Our Ref: AW/250/19/HH
Your Ref:

Town & Country Planning Act 1990 (as amended)
Town & Country Planning (Development Management Procedure) (England) Order 2015
Application for Planning Permission for Works or Extension to a Dwelling

Development Extension to driveway to front & widening driveway gate. This application affects the character & appearance of the Craigweil House Conservation Area.

Location 19 Kingsway Aldwick

Proposed

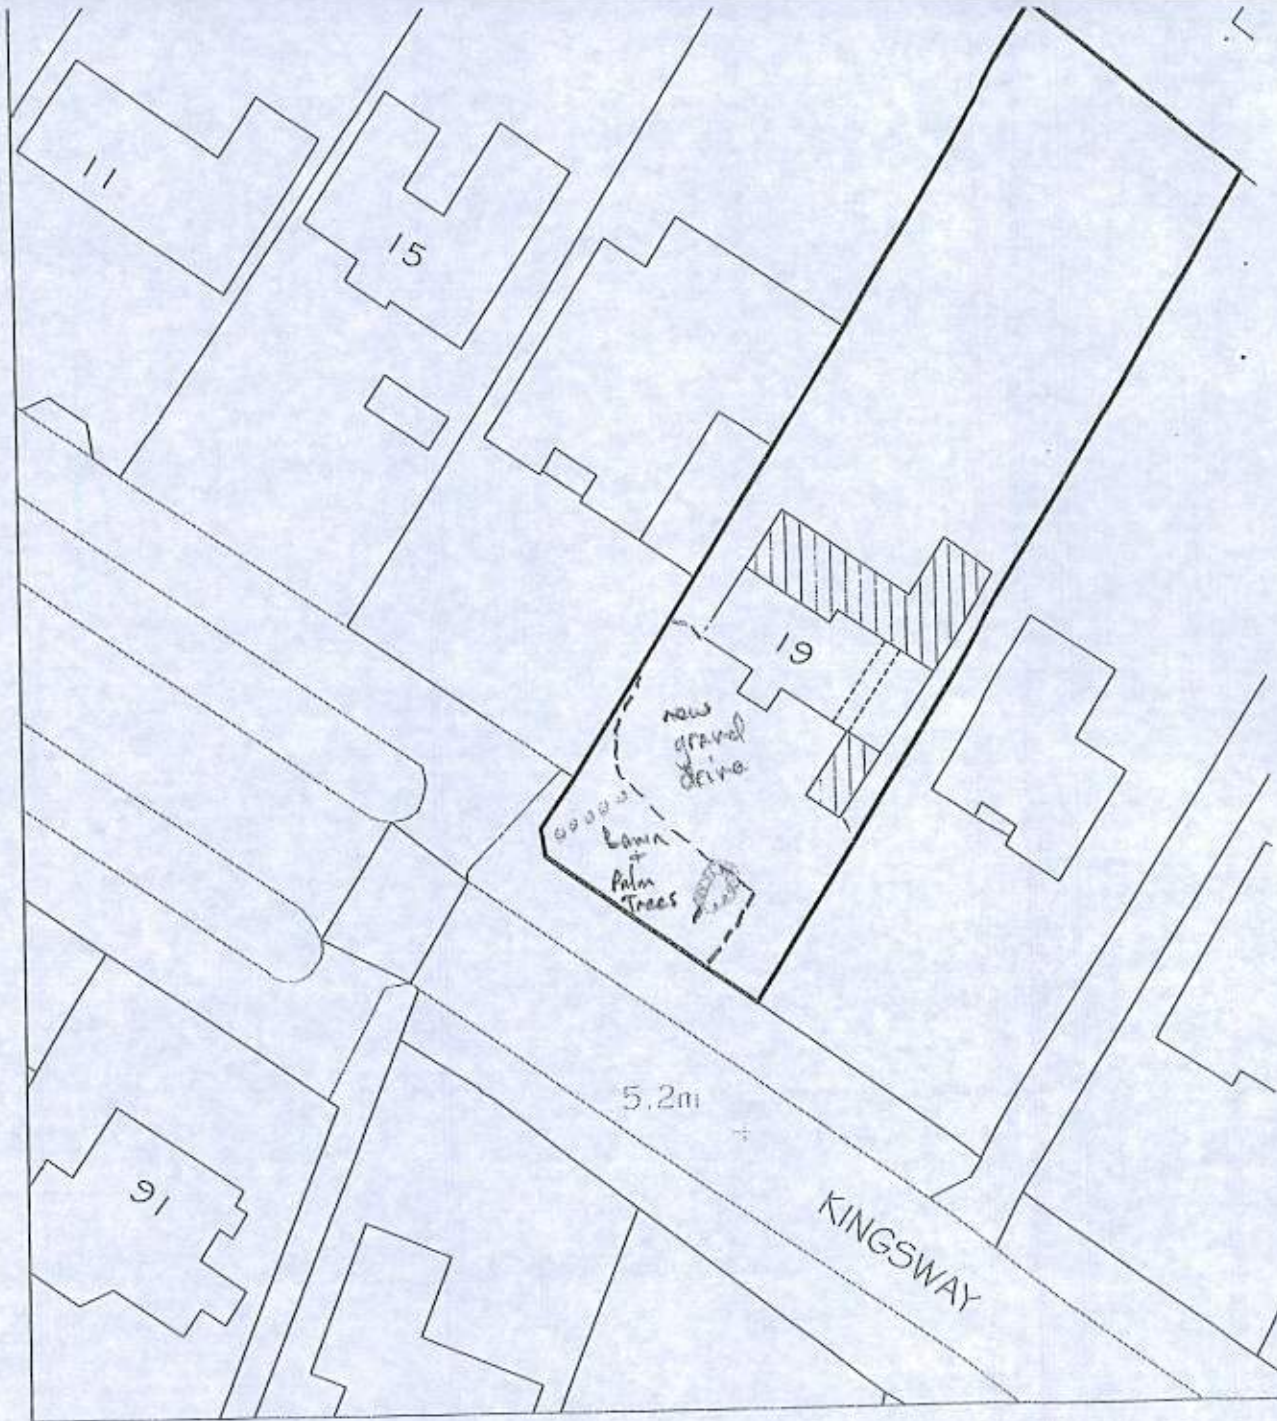
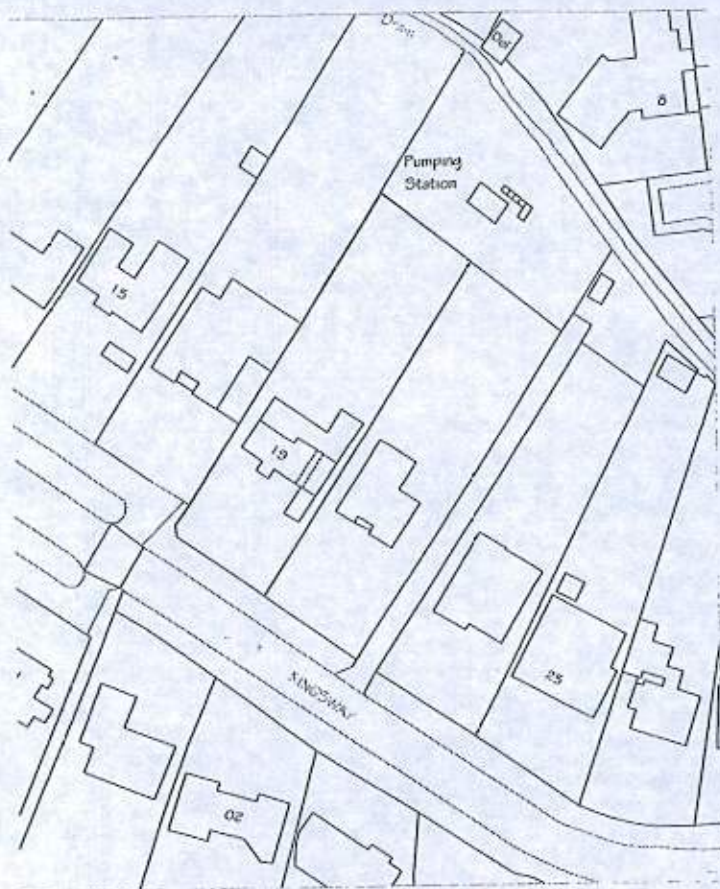
Location Plan Amend

Please red edge the site and provide a north point.

Block Plan Amend

Please provide a north point.

Please provide a north point on the site plan.
